Submission for Job: #2287 Lake Macquarie Yacht Club Expansion

Site: #1485 08_0045 Lake Macquarie Yacht Club

Re: Objection to the current plan
 Lake Macquarie Yacht Club Expansion 9 Ada Street, Belmont.

Re: MP 08_0045 Marina Expansion of Lake Macquarie Yacht Club

CLIENT: **LAKE MACQUARIE YACHT CLUB** DRAWING: **CAR PARK ALTERATIONS PLAN**

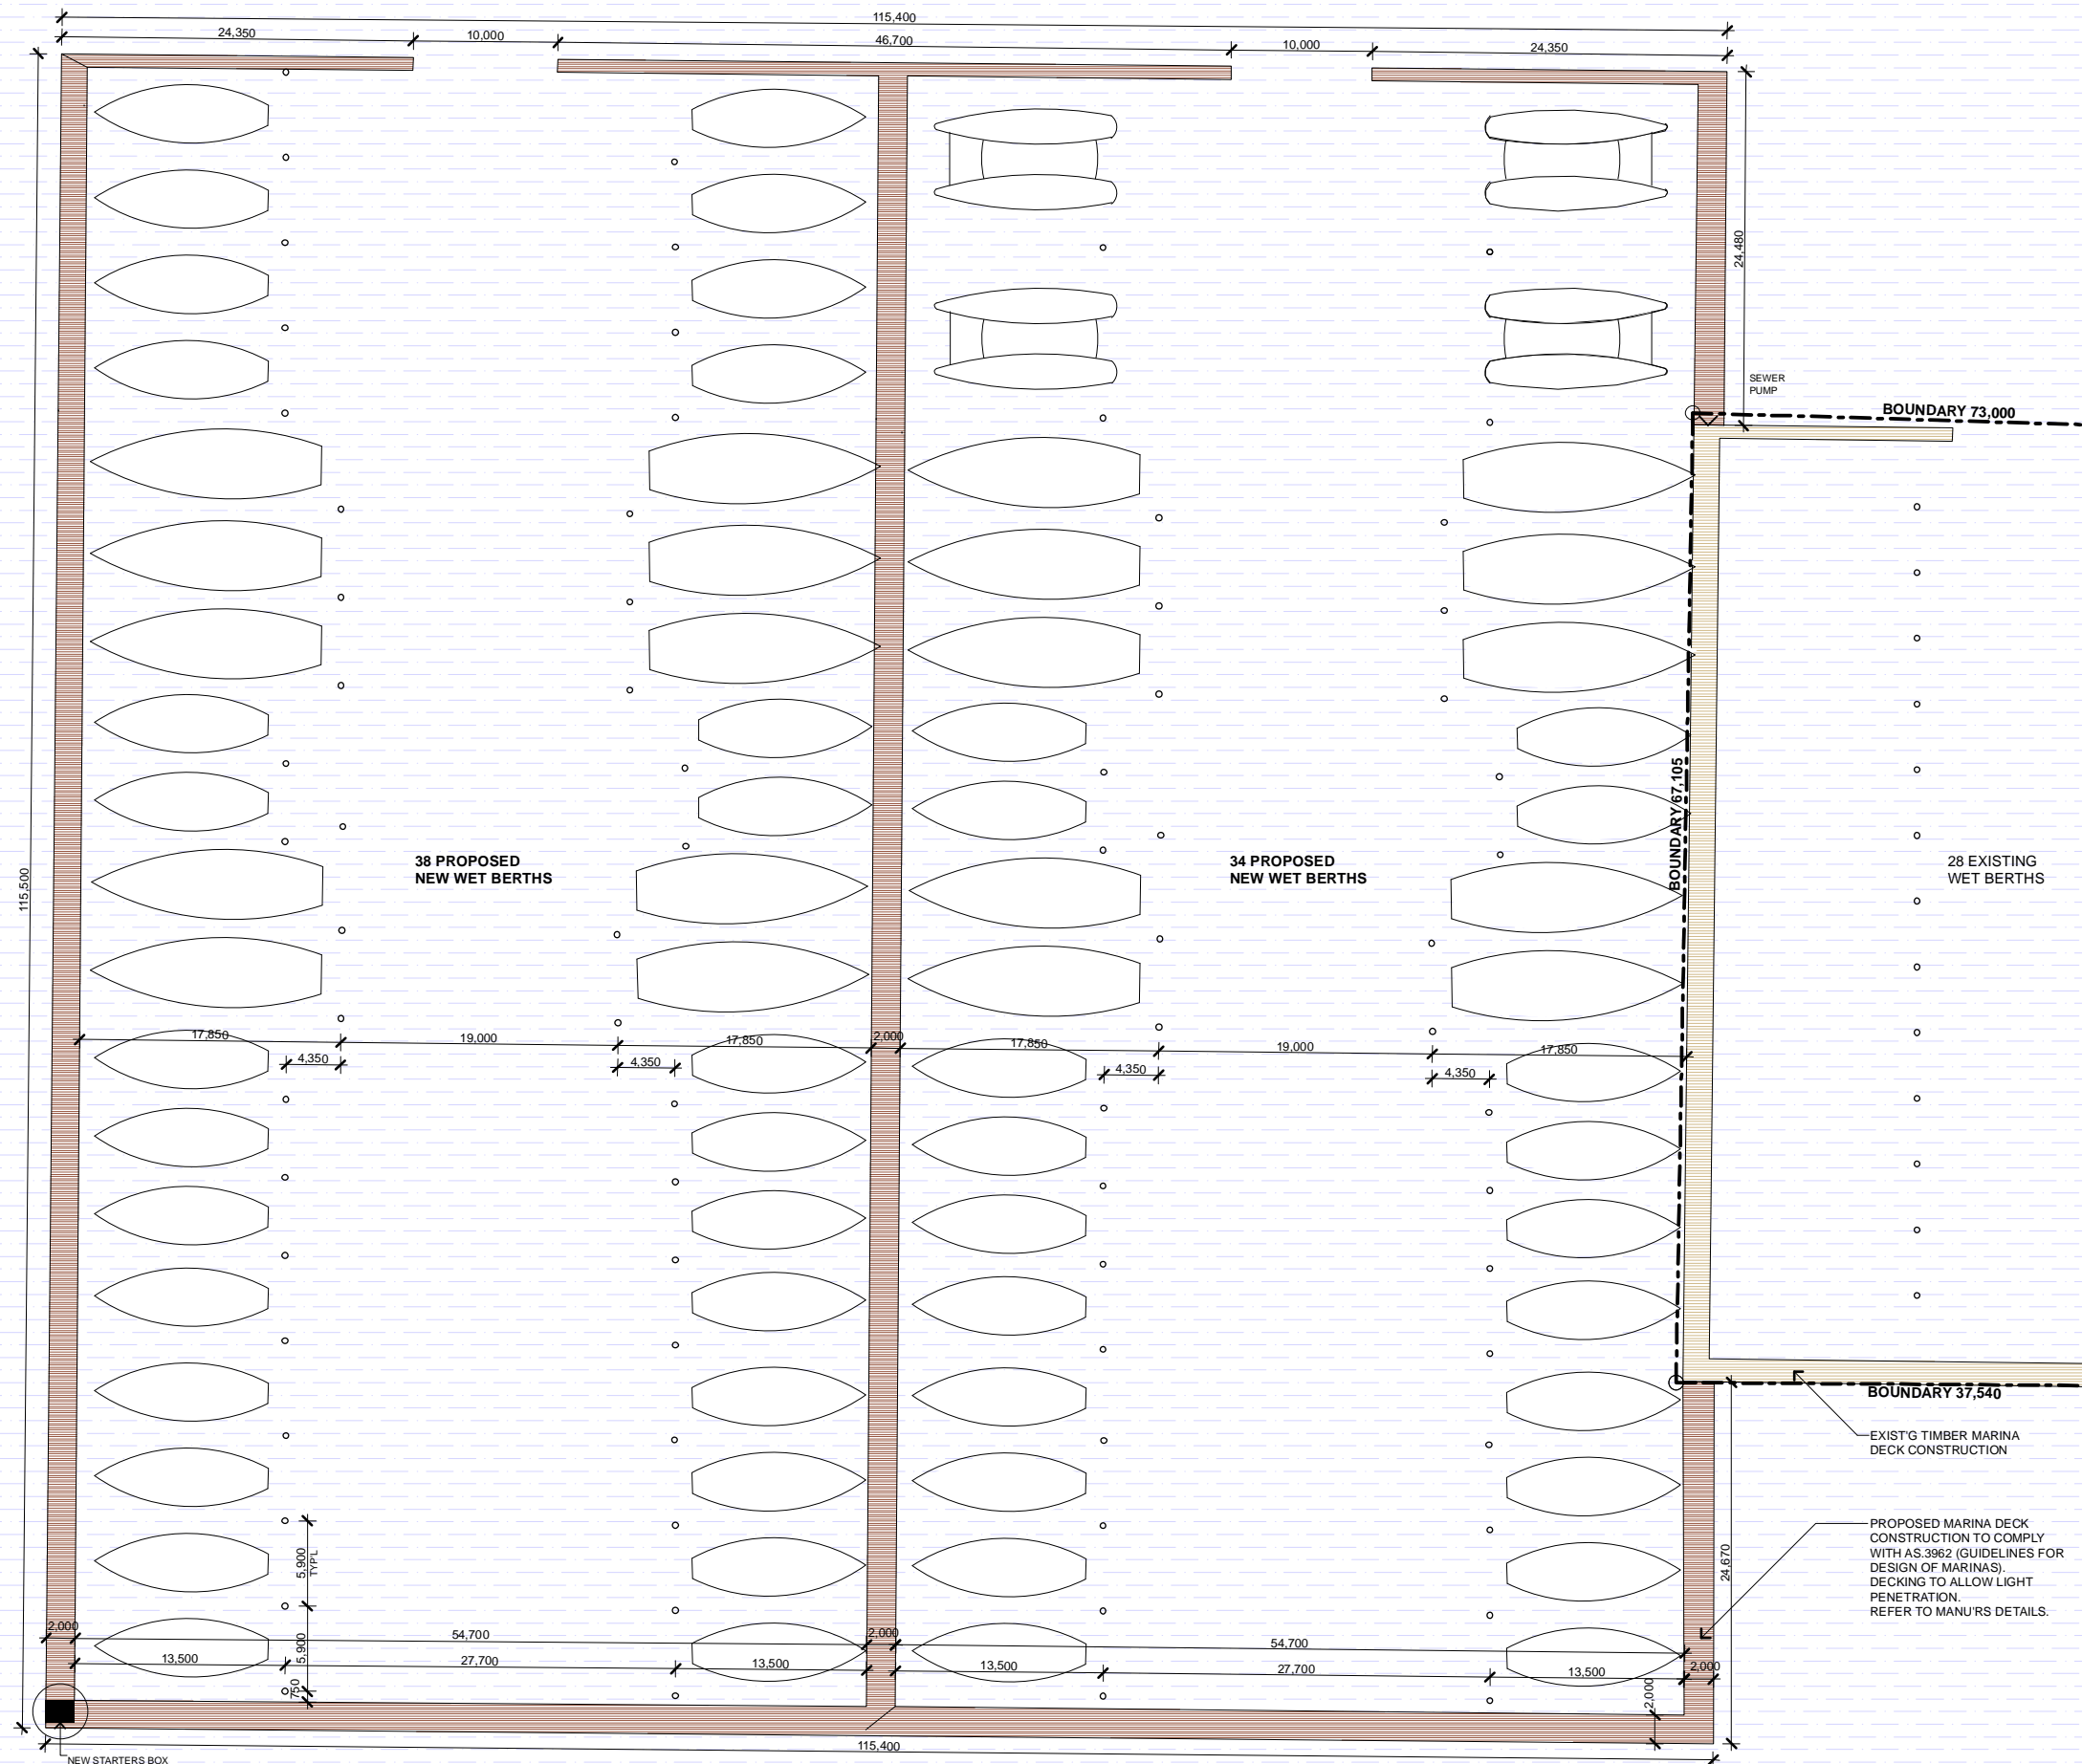
The proposal is to widen the existing car park and to provide additional car parking adjacent to Cullen Park. The number of parking spaces proposed is insufficient for the number of berths proposed. Another North/South under carpark waterway of similar width should be included to enable the sufficient flow of water.

The use of Cullen Park should be further investigated so as to provide enough parking but also provide the required resident/business access.

CLIENT: LAKE MACQUARIE YACHT CLUB  
DRAWING: MARINA EXTENSIONS PLAN

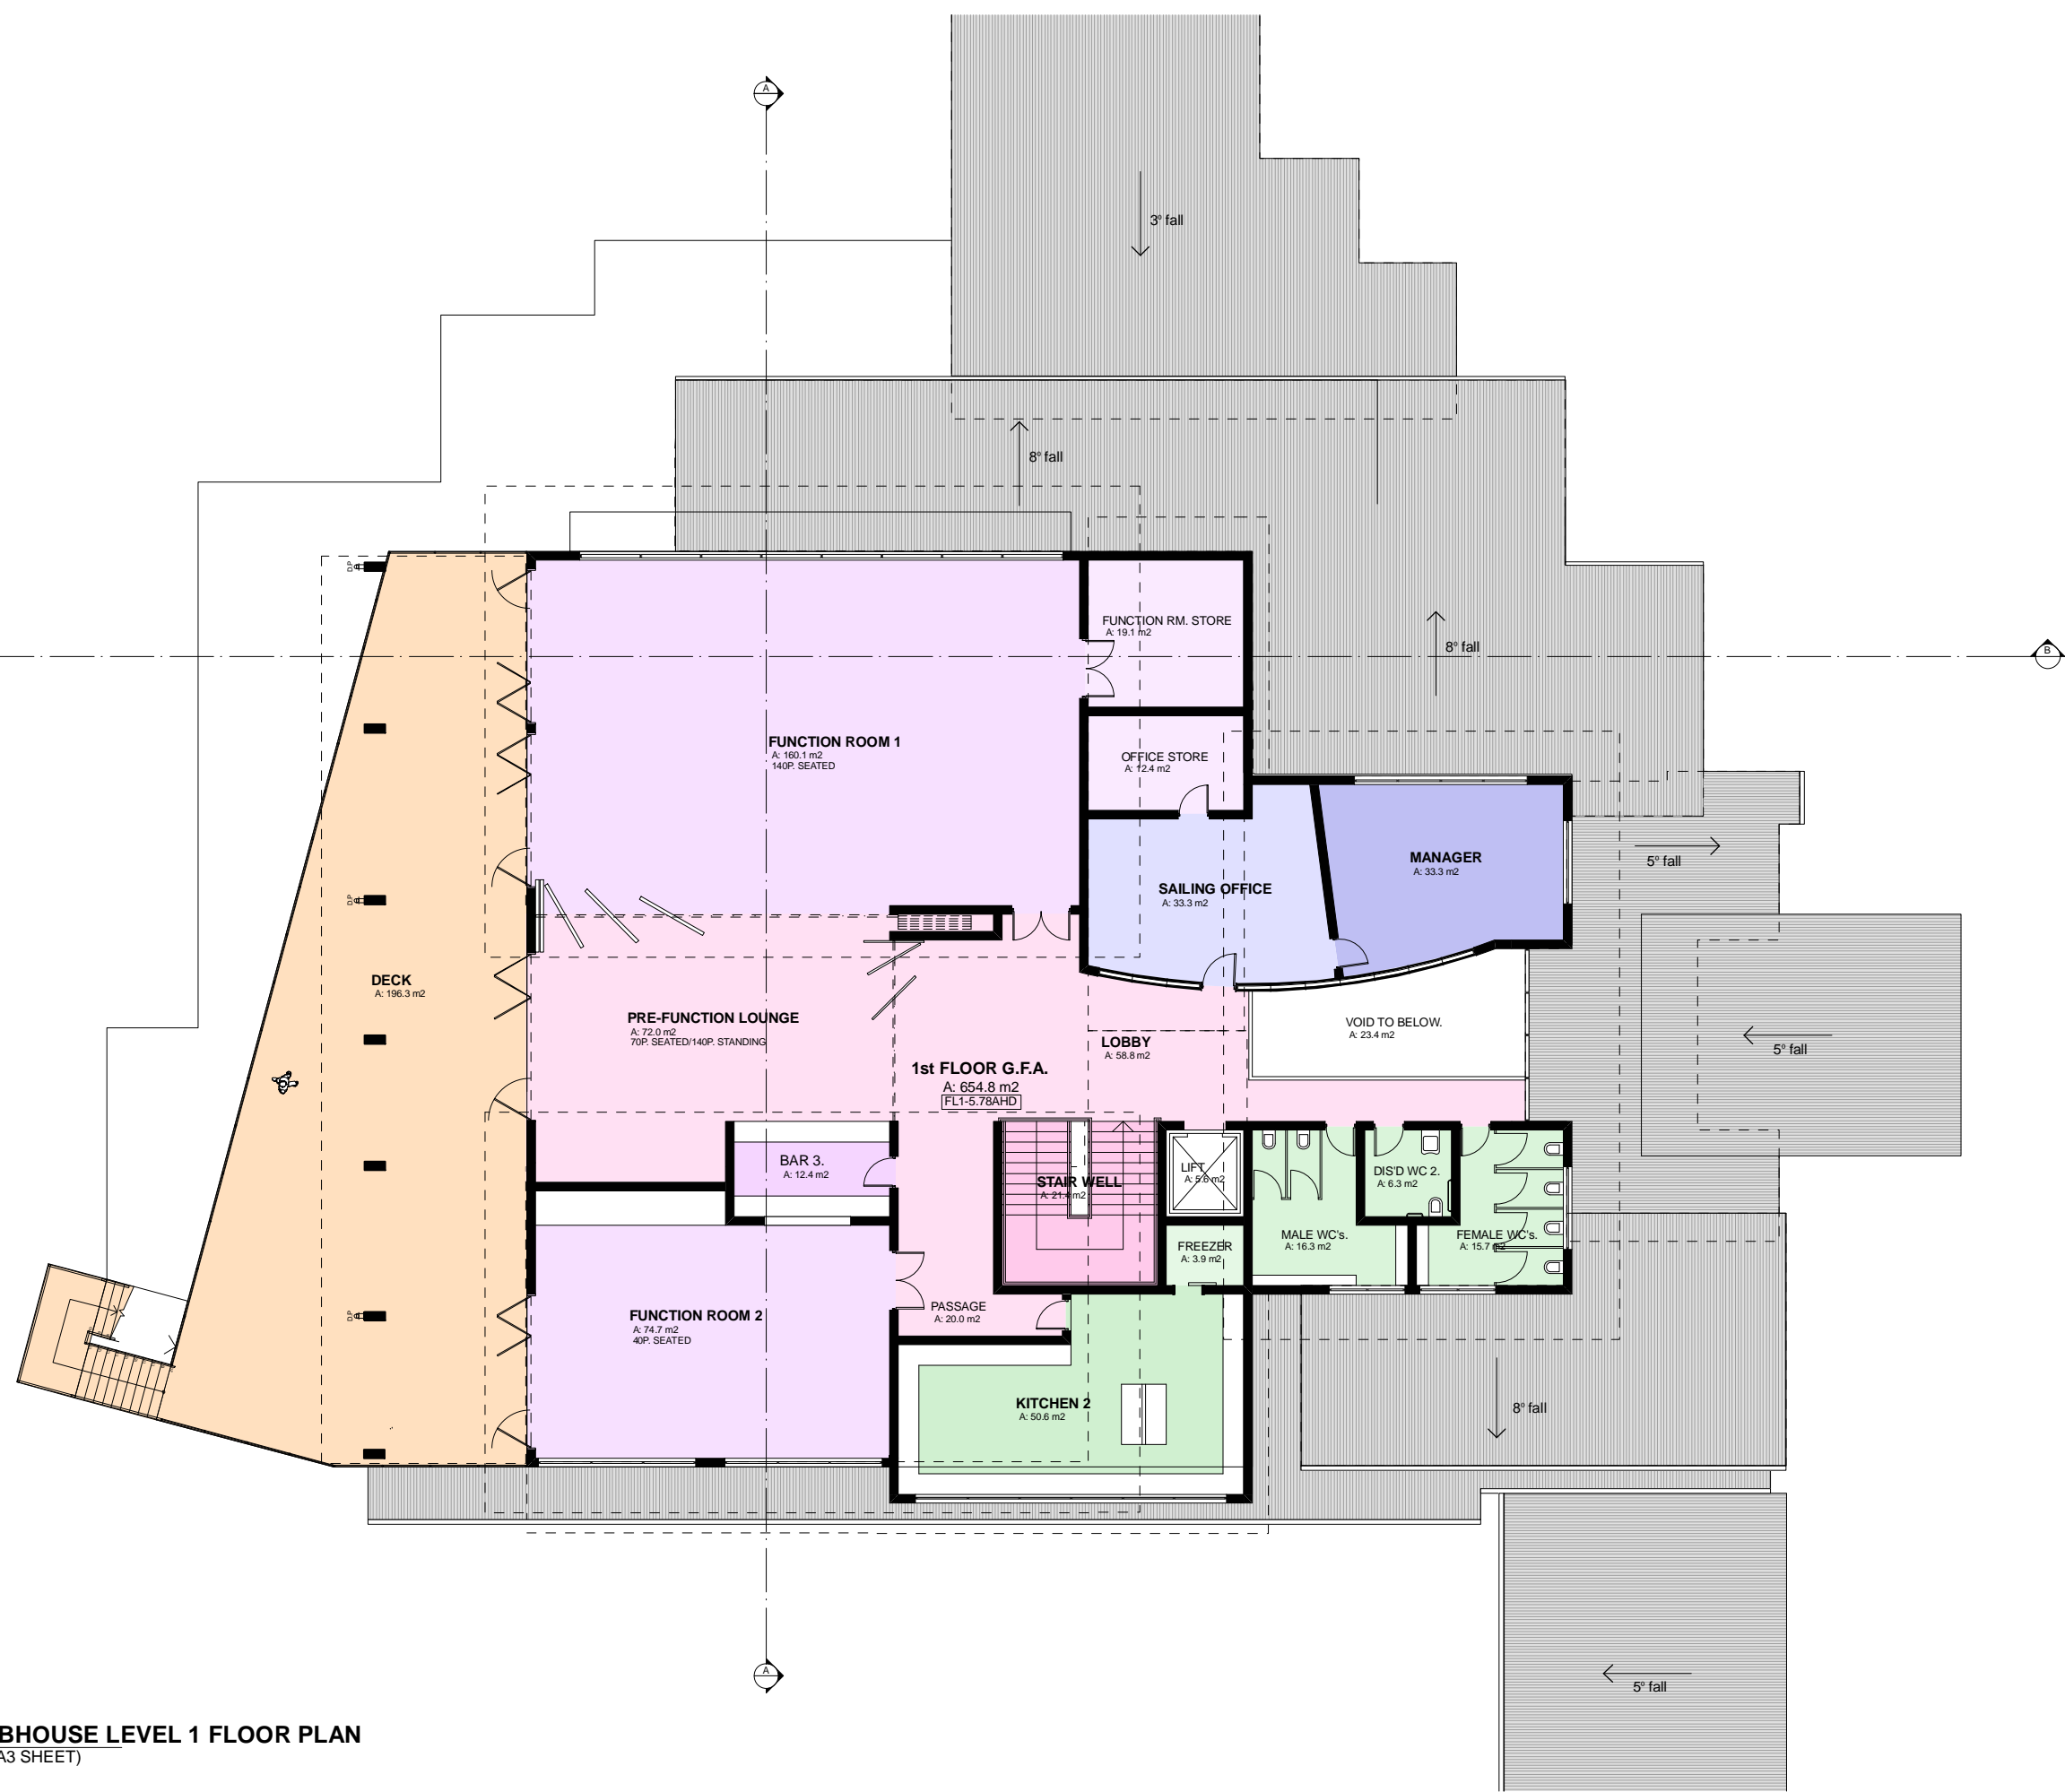
2. Excessive footprint

The physical footprint of the marina lease extending, encroaching out into this magnificent lake seems very excessive and I am confident a more efficient and effective design can be entertained. The extension of existing North/South aligned berths, in the order of 40m north and south, would still achieve the overall required number of berths to make this proposal financially viable. In effect resulting in a T shaped design. The principle and objective behind the building of marinas is to bring swing moorings into the development. This T shaped design will enable the club to surrender its 18 swing moorings and include them in the new marina berths.
